**From:** [Dale, Louise Miss \(DIO Estates-SafegdgMgr2\)](#)  
**To:** [A303 Sparkford to Ilchester](#)  
**Subject:** 20190503: A303 Sparkford to Ilchester Dualling (TR010036) MOD Response  
**Date:** 03 May 2019 13:45:55  
**Attachments:** [20190503\\_10044194\\_RNAS\\_Yeovilton\\_PINS\\_Questions.pdf](#)

**Your Reference:** TR010036  
**Our Reference:** 10044194

**Application by Highways England for an Order granting Development Consent**

This letter is written in response to the Examining Authority's written questions and requests for information issued on the 16<sup>th</sup> April 2019 in which the Ministry of Defence /DIO was asked two specific questions at 3.0.6 and 3.10.20. These two questions are set out in full below with the relevant response provided in each case.

Figure 2.2 Main site compound.

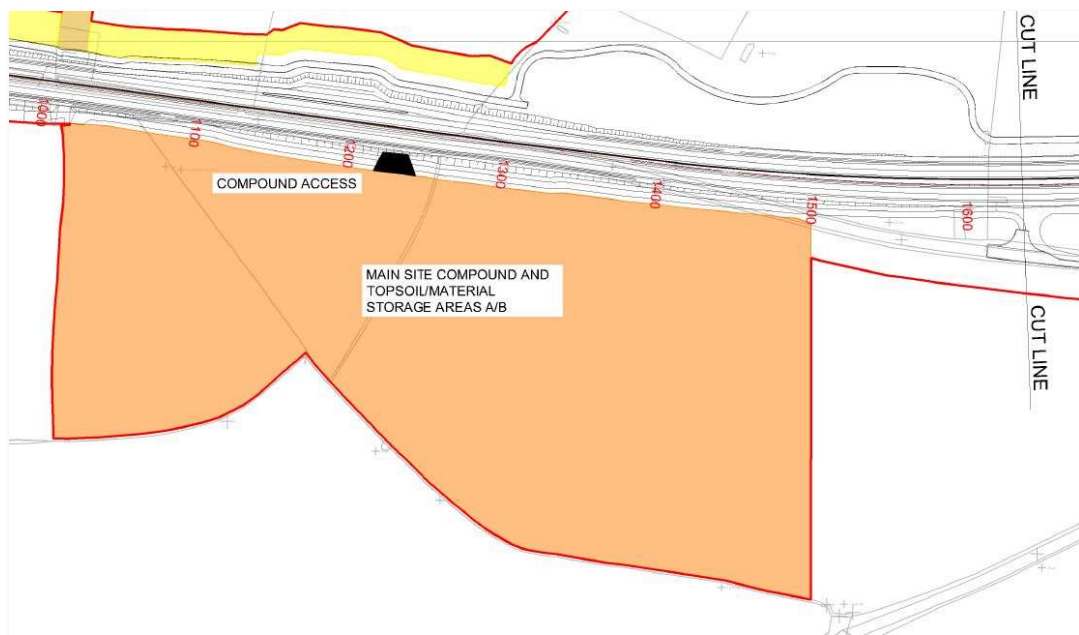
The applicant has carried out an assessment on the construction compound between Podimore and Camel Hill to identify any infringements by the construction equipment and infrastructure of the protected airspace surrounding RNAS Yeovilton known as the Obstacle Limitation Surface (OLS). The MOD does not agree with the results of this assessment. The applicant's assessment was based on the standards outlined by the International Civil Aviation Organization (ICAO) however the MOD uses military standards known as RA3500.

The MOD is also engaged with Highways England regarding the proposed works compound on land adjacent to the end of RNAS Yeovilton's main runway. The MOD raised concerns due to the height of the proposed equipment and infrastructure to be stored there, some of which will be approx. 21m high and will occupy the statutory aerodrome height and technical safeguarding zones surrounding RNAS Yeovilton. These zones ensure air traffic approaches and the line of sight of navigational aids and transmitters/receivers are not impeded.

The airspace above and around aerodromes is safeguarded to maintain an assured, obstacle free environment for aircraft manoeuvre and is known as the Obstacle Limitation Surface (OLS). This development site sits beneath the approach and take off climb OLS surfaces for RNAS Yeovilton. The approach and take off climb surfaces need to be kept free from obstruction from tall structures to ensure that aircraft transiting to and from or circuiting the aerodrome can do so safely.

The MOD carried out an assessment and identified the height of the proposed construction equipment and infrastructure will infringe the approach OLS surface. The MOD raised concerns with the site identified to store construction equipment and infrastructure as there cannot be any infringements of the OLS.

The proposed-compound is also within the area protecting the operation of the Instrument Landing System (ILS) and the Precision Approach Radar (PAR) that surveys the approach to runway 22 at RNAS Yeovilton.

Based on information submitted, the height of the compound equipment and infrastructure would create an infringement of the radars safeguarded arcs; affecting the performance of the PAR and ILS radars. An infringement would affect the stations ability to operate runway 22 causing detrimental impacts to military operations.

To prevent an infringement of the Obstacle Limitation Surface and the safeguarded arcs protecting the Precision Approach Radar (PAR) and Instrument Landing System (ILS) no structure or equipment should exceed ..... m Above Ground Level (AGL).
